Subject: RE: 40 Elm Grove, Barnham BN/95/21/DOC

Subject: BN/95/21/DOC

Engineers Comments Regarding Surface Water Drainage

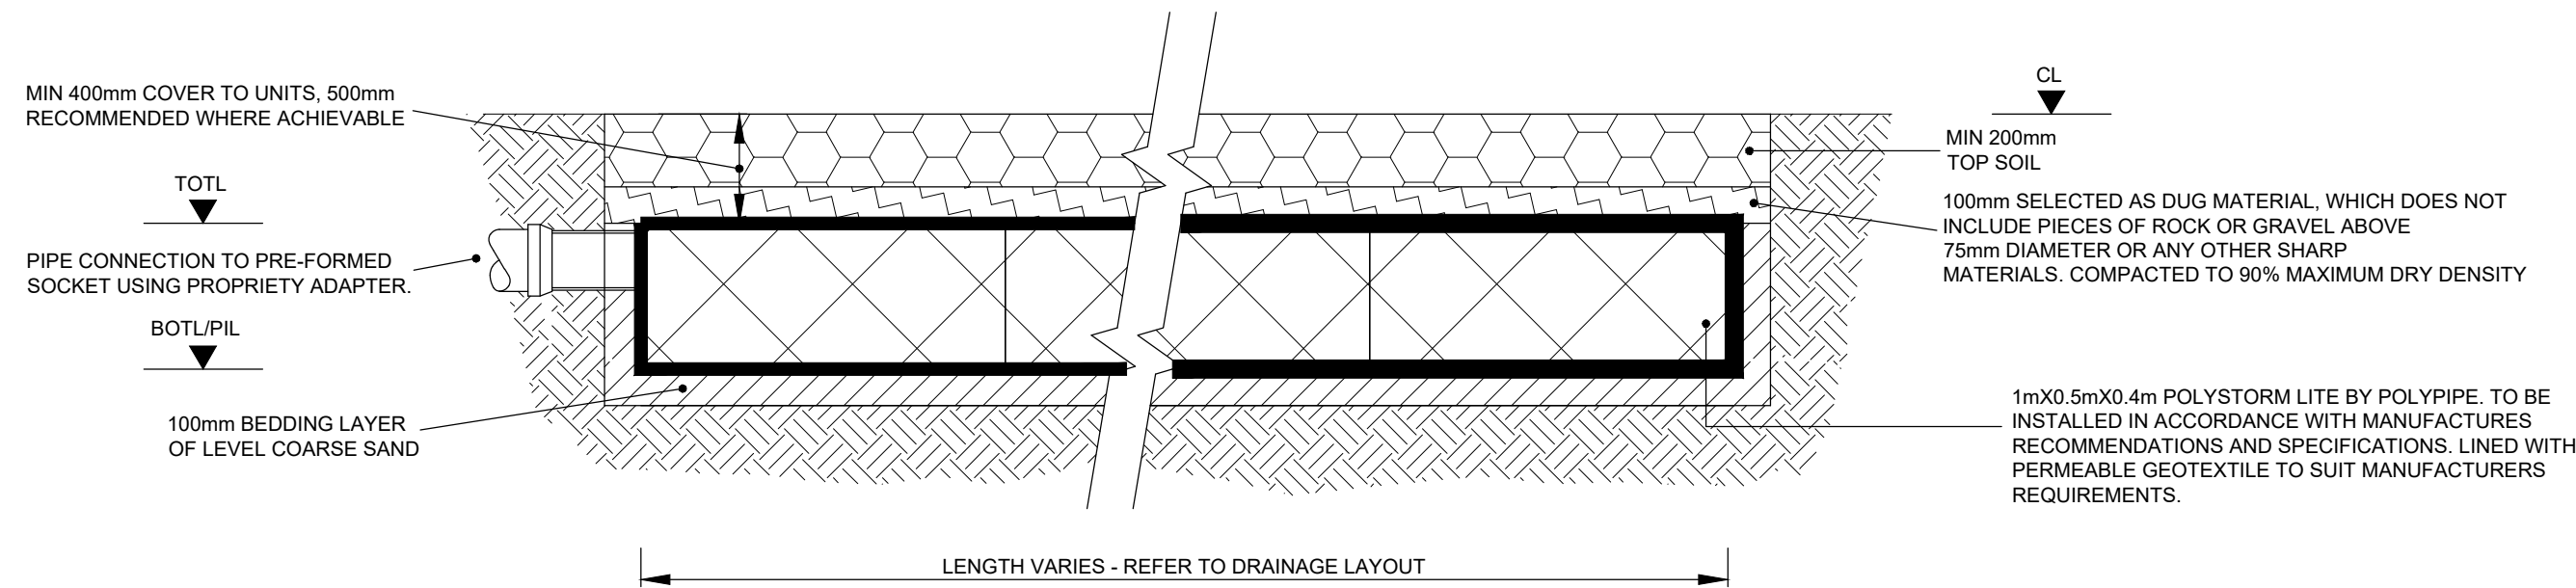
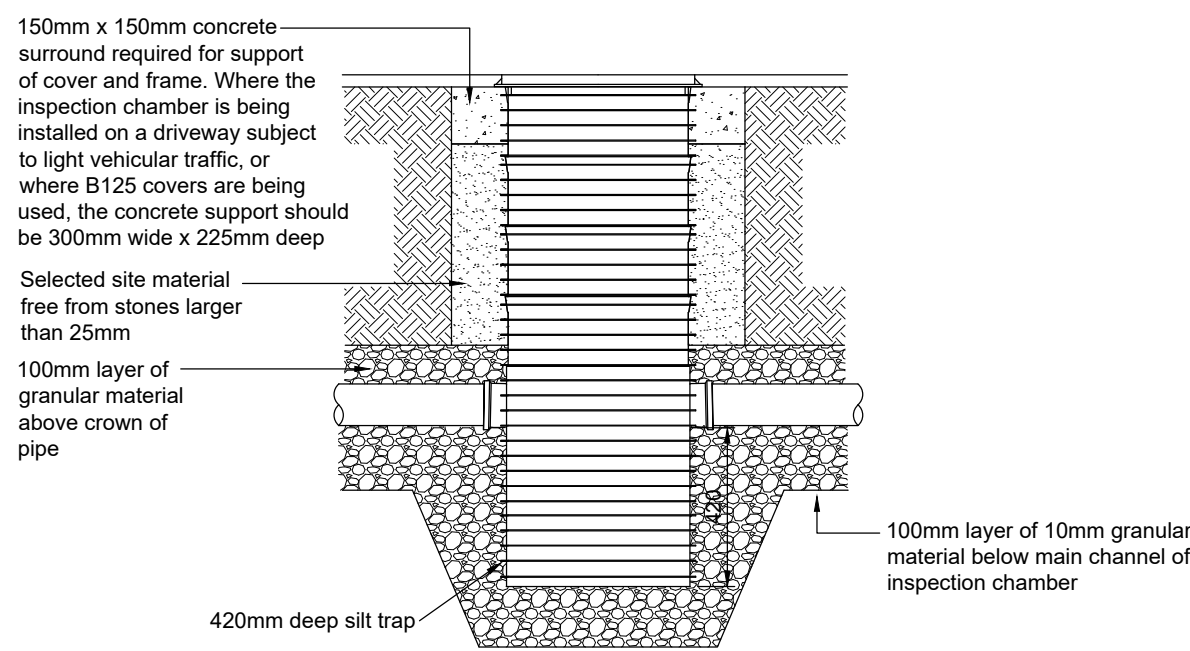
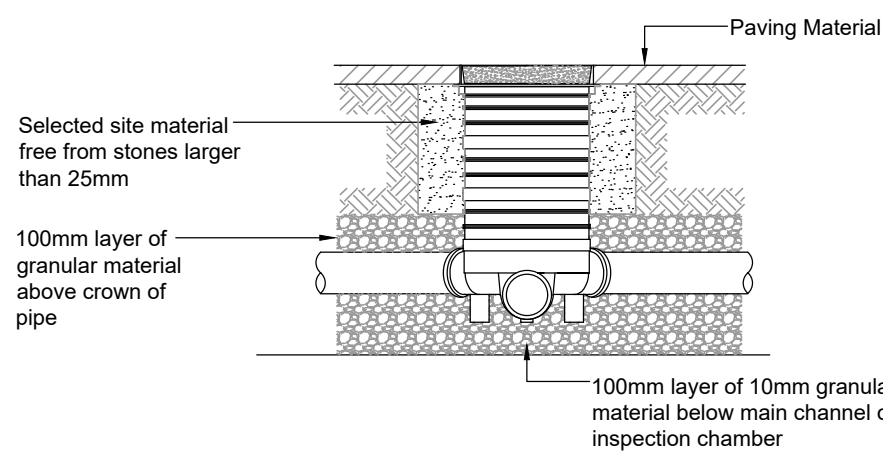
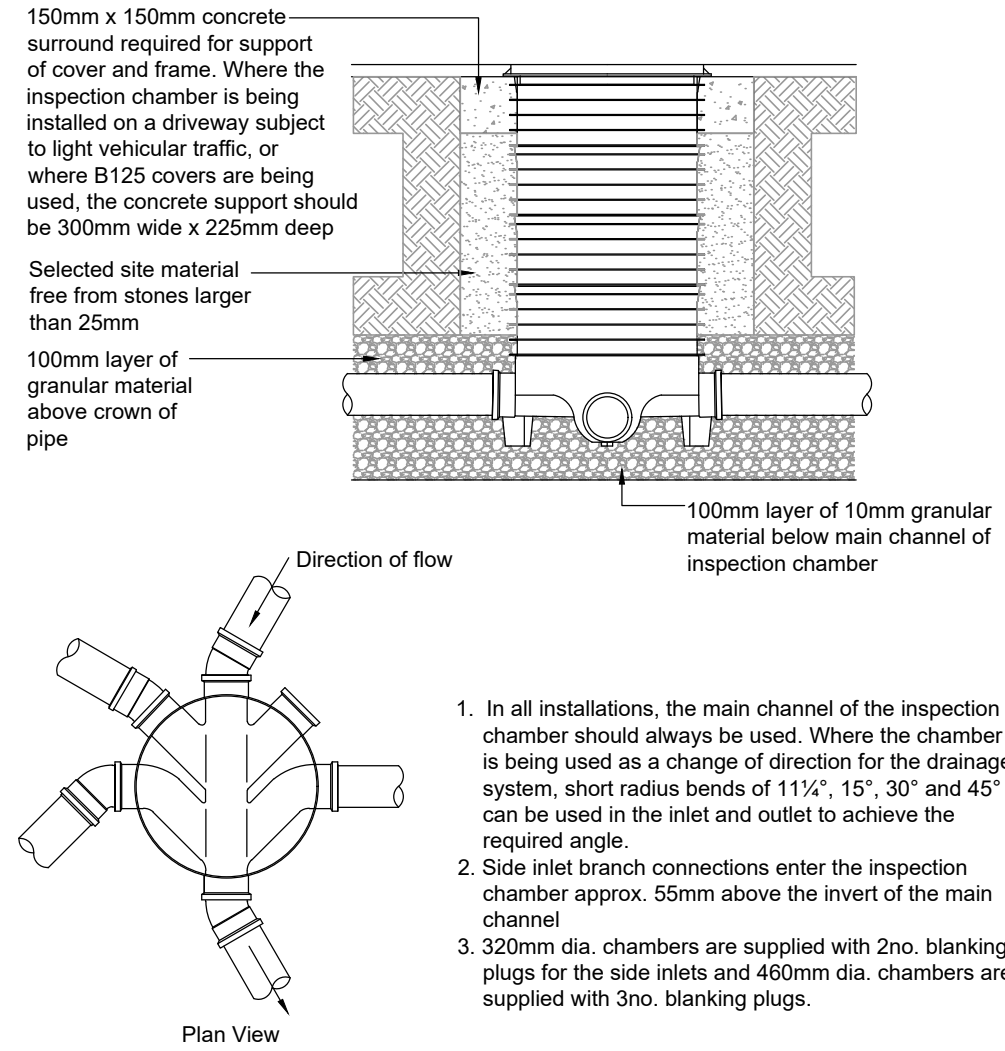
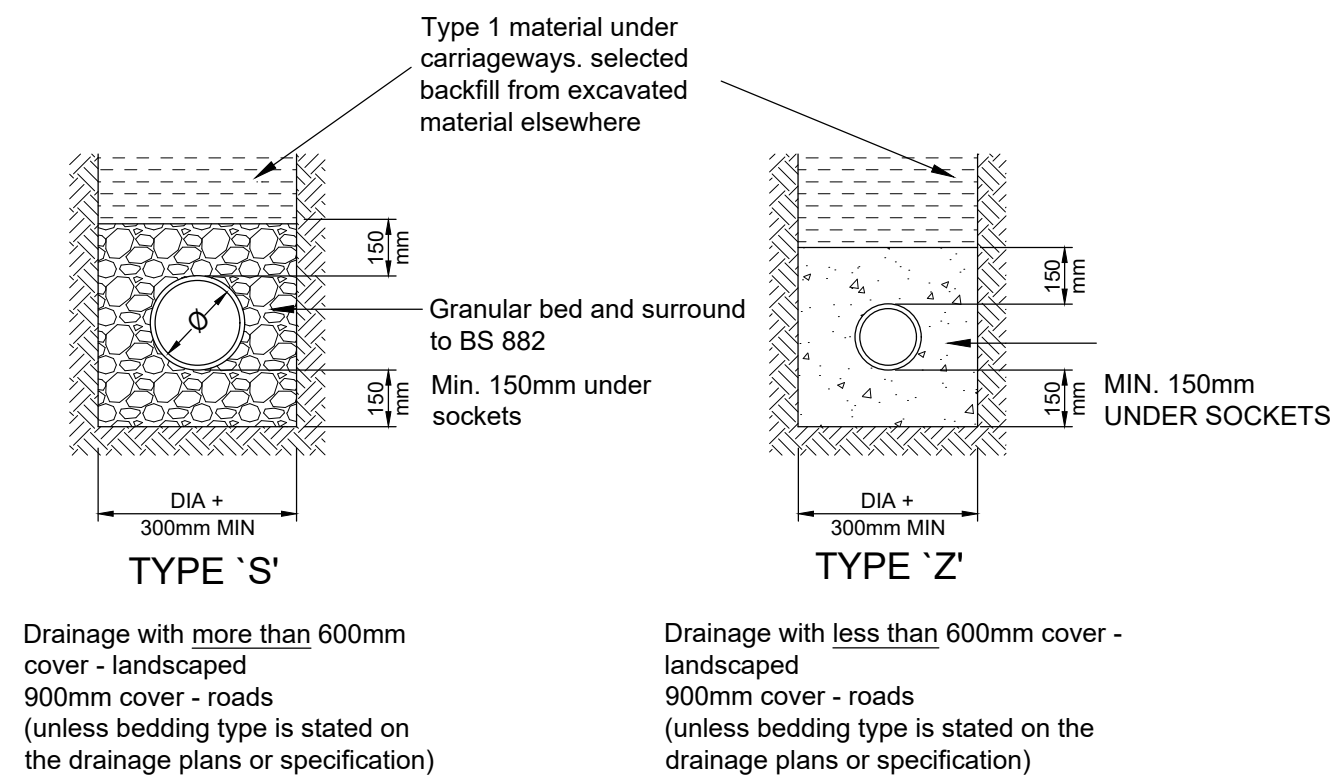
1. Please can you confirm the impermeable area used for the calculations. We would normally expect an impermeable area plan, however noting this on the layout should be sufficient as it is the whole dwelling.
2. Please can you adjust the pipe junctions on the western side of the dwelling so that they are angled in the direction of flow. Please also include a detail of the pipe junctions.
